Please ask for: Sian Eggington
Email: sian.eggington@terraquest.co.uk
Telephone: 0121 2341390
Our Ref: P/90/20/HH
Your Ref:
Date: 15th September 2020

Application for Planning Permission for Works or Extension to a Dwelling

Development: Single storey flat roof side/rear extension .
Location: 7 Barons Mead Pagham PO21 4SF

EXISTING FLOORPLANS TO: 7 BARONS MEAD, PAGHAM, FOR MR. D. ROWLINSON

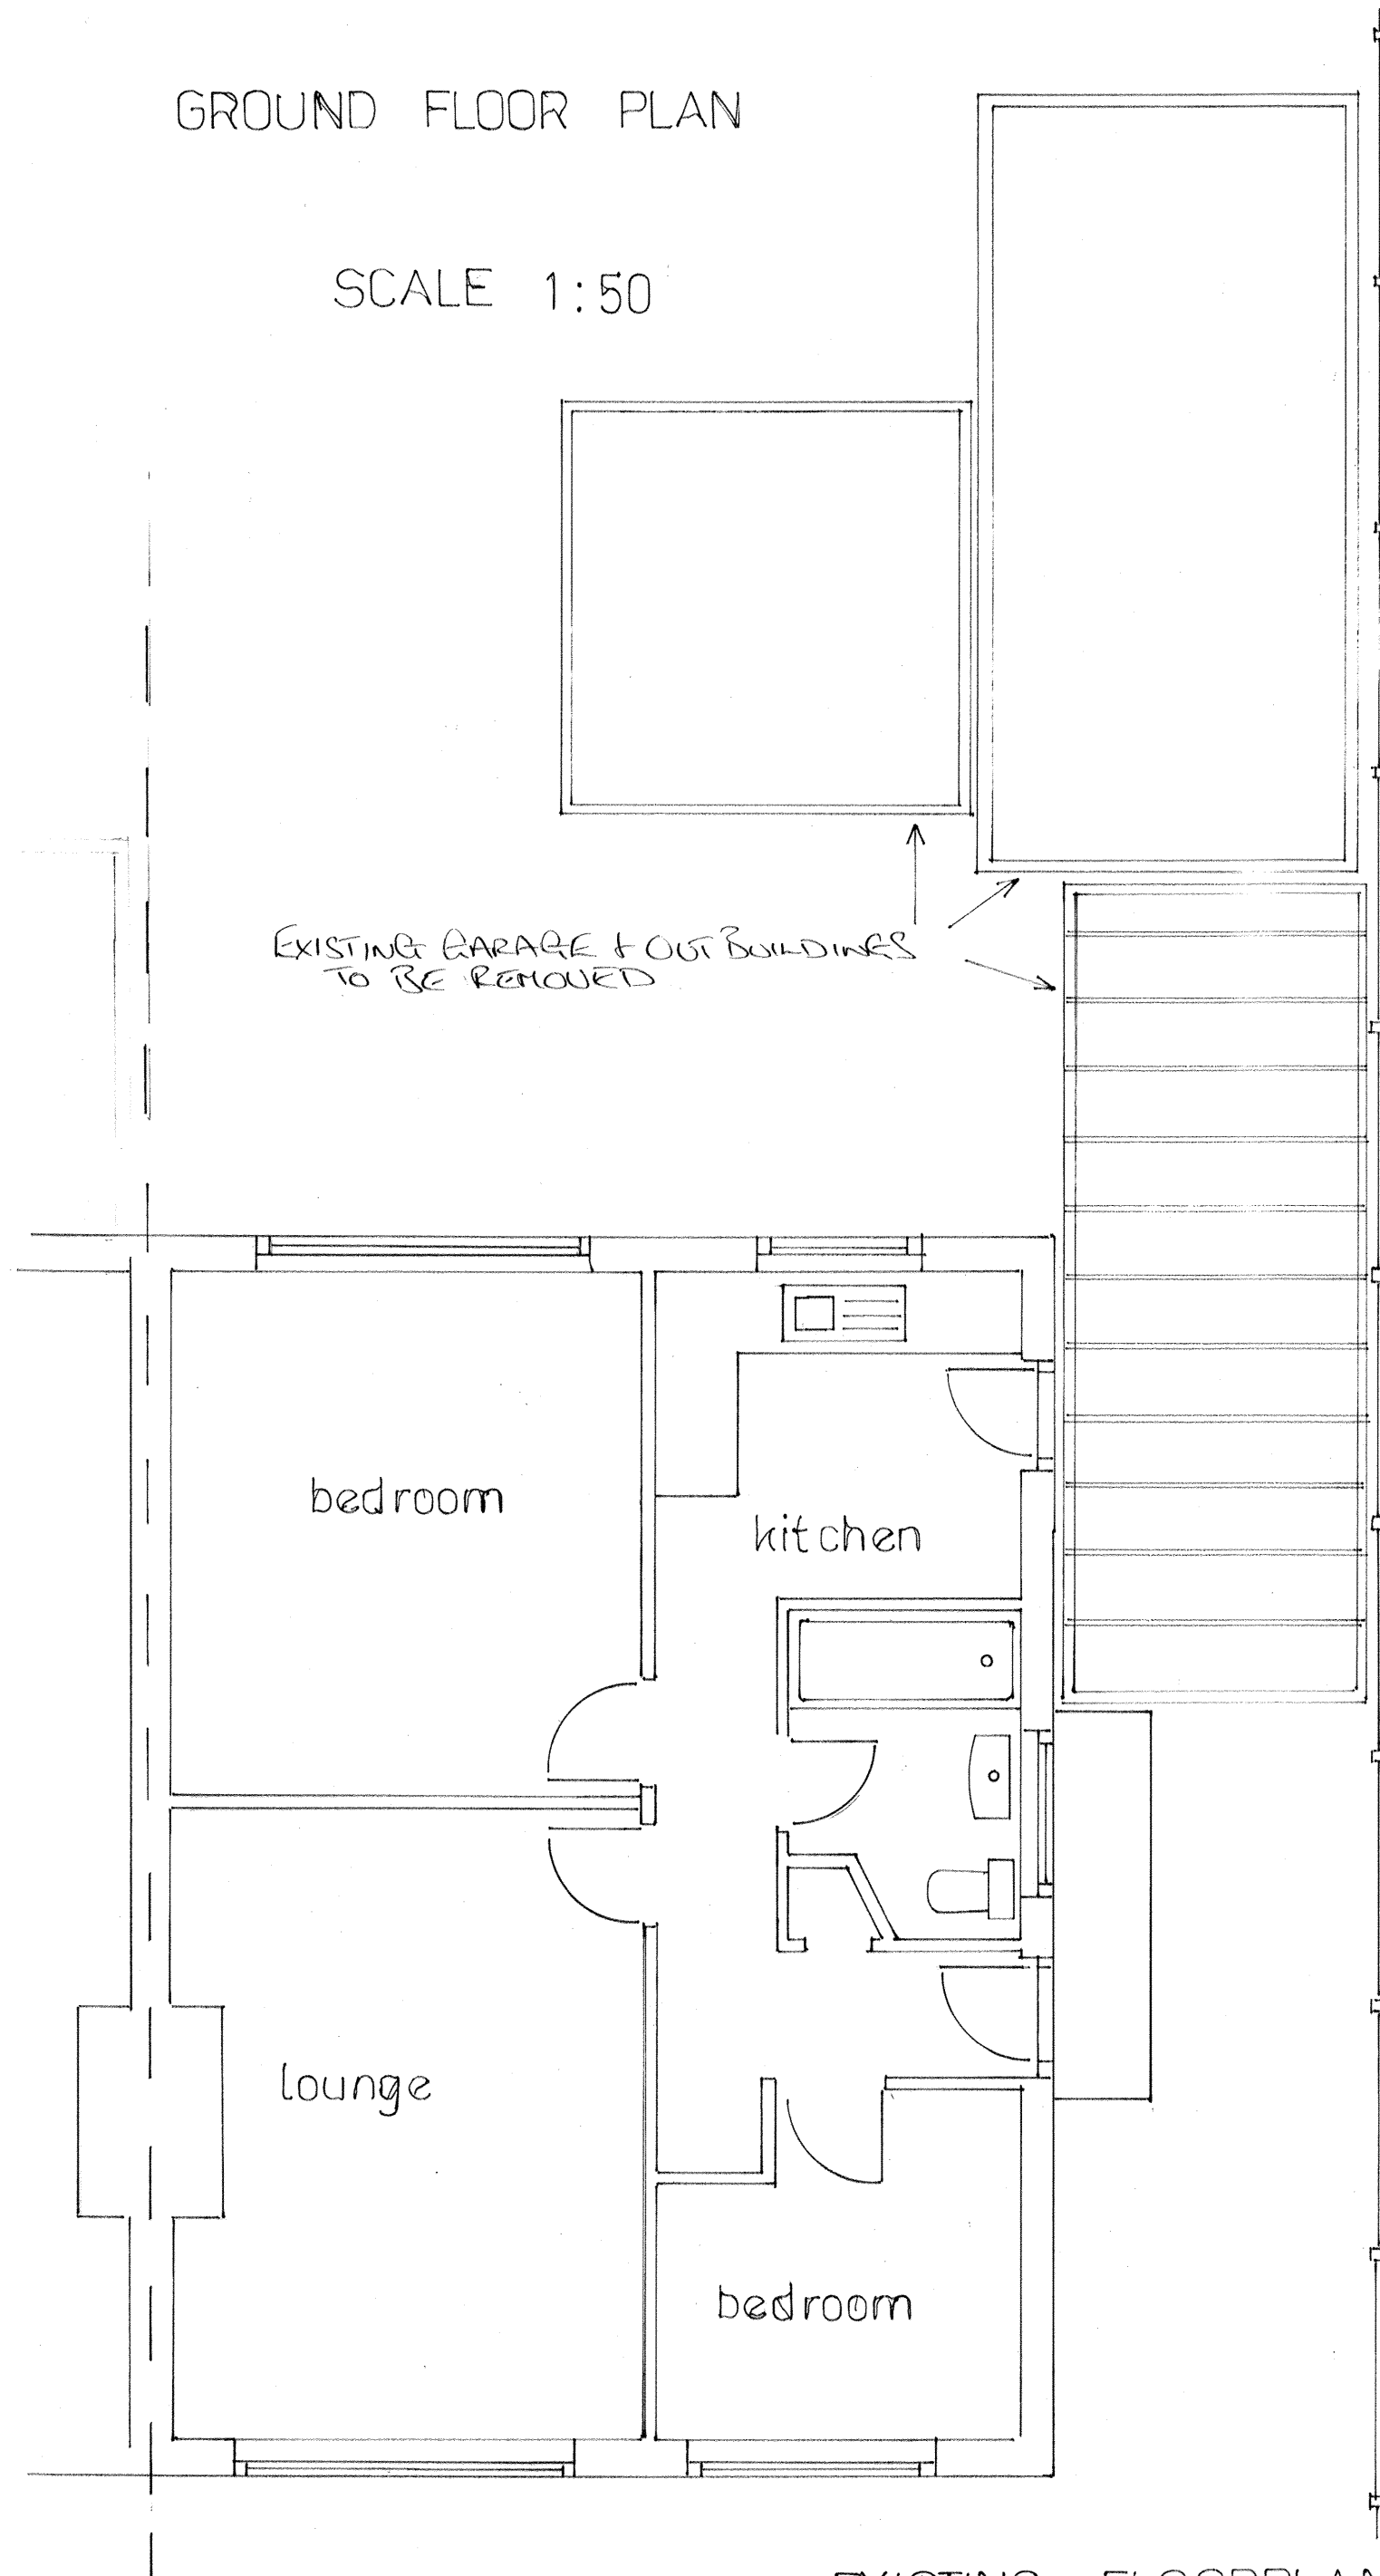
Please submit existing elevations and floor plans at a scale of 1:50 or 1:100. Further details can be found in the Validation Requirements List.
